INFRASTRUCTURE PLANNING
THE INFRASTRUCTURE PLANNING (EXAMINATIONS PROCEDURE) RULES 2010
THE THANET EXTENSION OFFSHORE WIND FARM ORDER

Comments on Responses to Action Points from ISH2
Submitted on behalf of the Port of London Authority and Estuary Services Limited
(Rule 8 letter 18 December 2018)

| Document Ref. | PLA 8 / ESL 8 |
| Date | 5 February 2019 |

Run 4

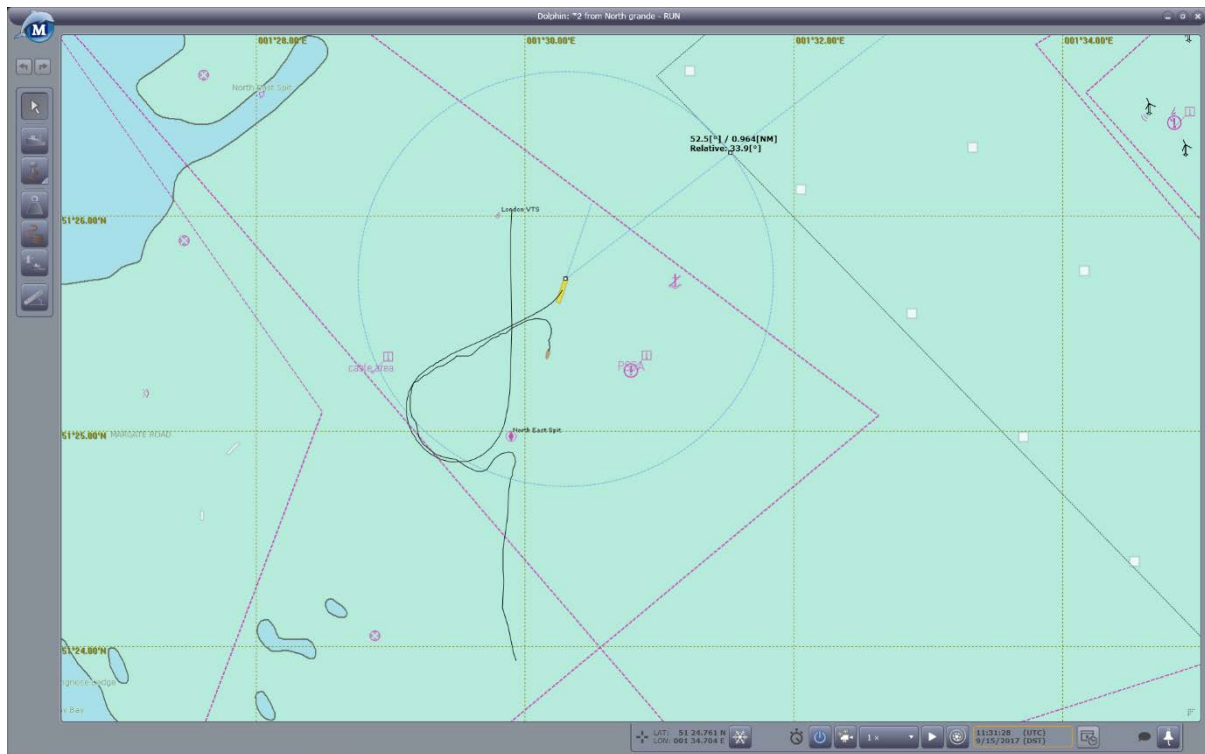
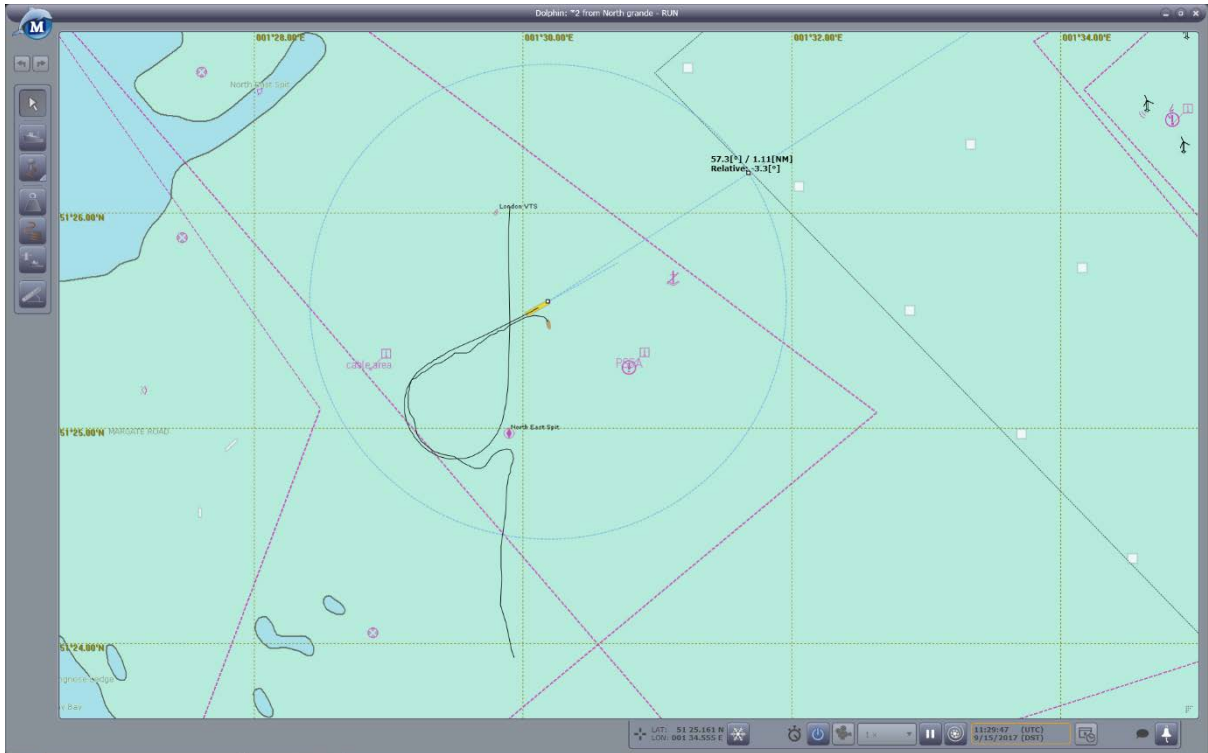
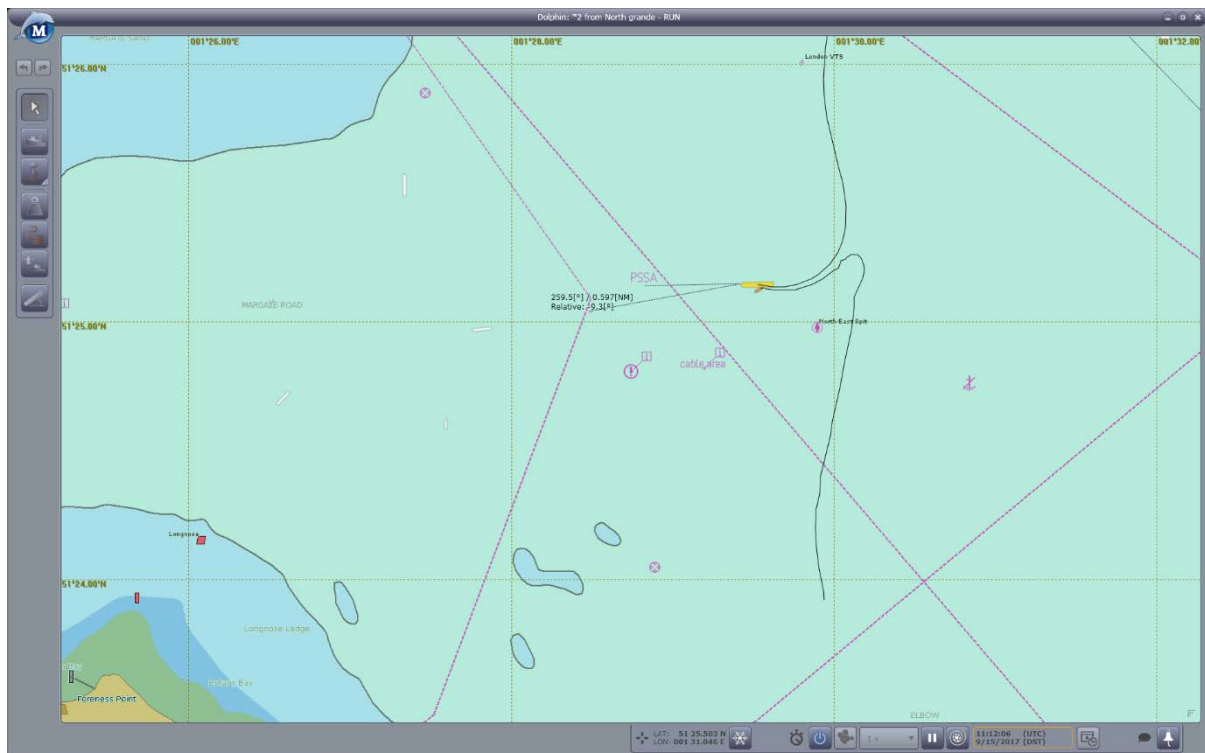
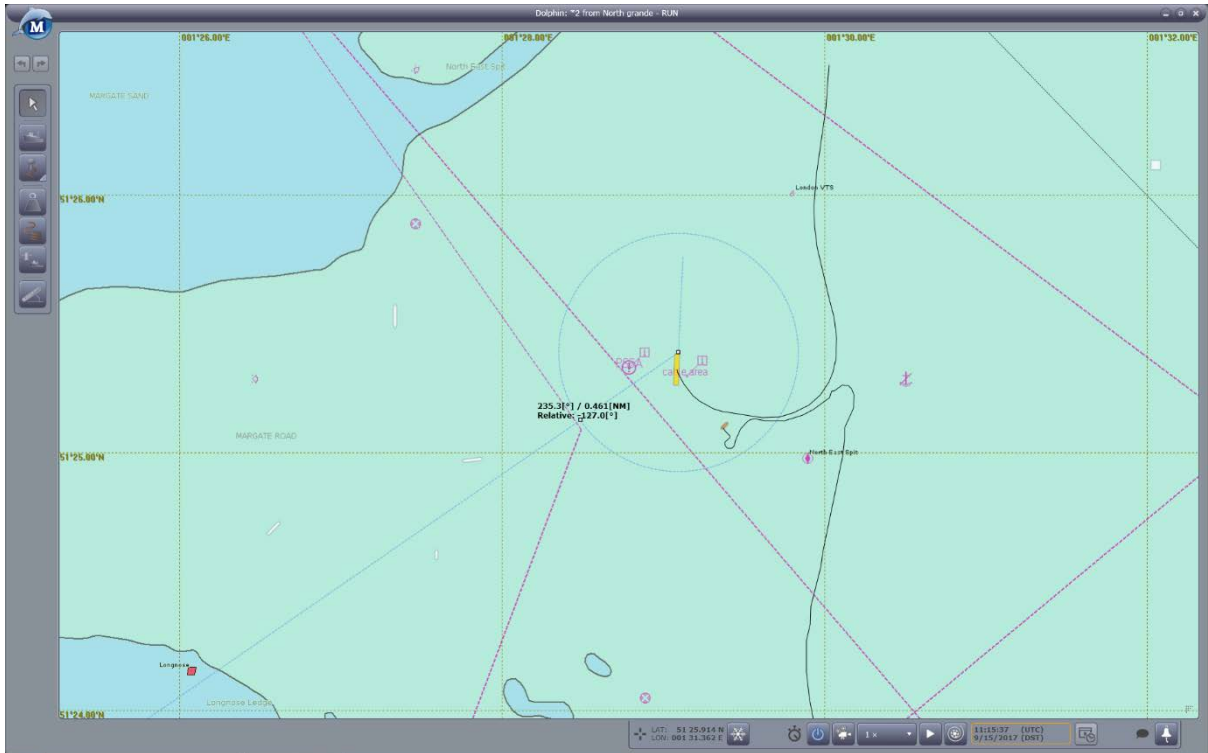
| Action Point | Response summary/extract | PLA/ESL comments |
|--------------|--|---|
| 13 | <p>“the Applicant wishes to note that as concluded in the Pilot Transfer Bridge Simulation Report (PINS Ref APP-/ Application ref 6.4.10.2) all simulation runs were completed successfully, and Pilot transfer operations continue to be feasible at North East Spit Station across the full range of operational conditions even with the reduced navigable sea room caused by the extended wind farm layout.”</p> | <p>The PLA and ESL have raised extensive comments on the reliability of the Pilot Transfer Bridge Simulation in their Deadline 1 submissions.</p> <p>However, the Applicant states that all simulation runs were completed successfully. This is not accurate: the Pilot Transfer Bridge Simulation Report states, at paragraph 6, that “13 of the 14 runs were successful and 1 run (no.4) was judged to be marginal”. Even if the test conditions were representative of real life conditions, which the PLA and ESL do not accept, a 1 out of 14 ‘marginal’ result would in practice be a high risk and high stress environment for working pilots.</p> <p>The PLA and ESL disagree with the ultimate conclusions being drawn from the Simulation Report. It cannot be said that pilotage operations continue to be feasible “across the full range of operational conditions” because only very</p> |

| Action Point | Response summary/extract | PLA/ESL comments |
|--------------|--|---|
| | | <p>limited, optimal conditions were tested during the simulation. The fact that even in these optimal conditions and without human error being factored in one in 14 of the runs was marginal illustrates that the proposed wind farm extension presents a significant increase in risk.</p> |
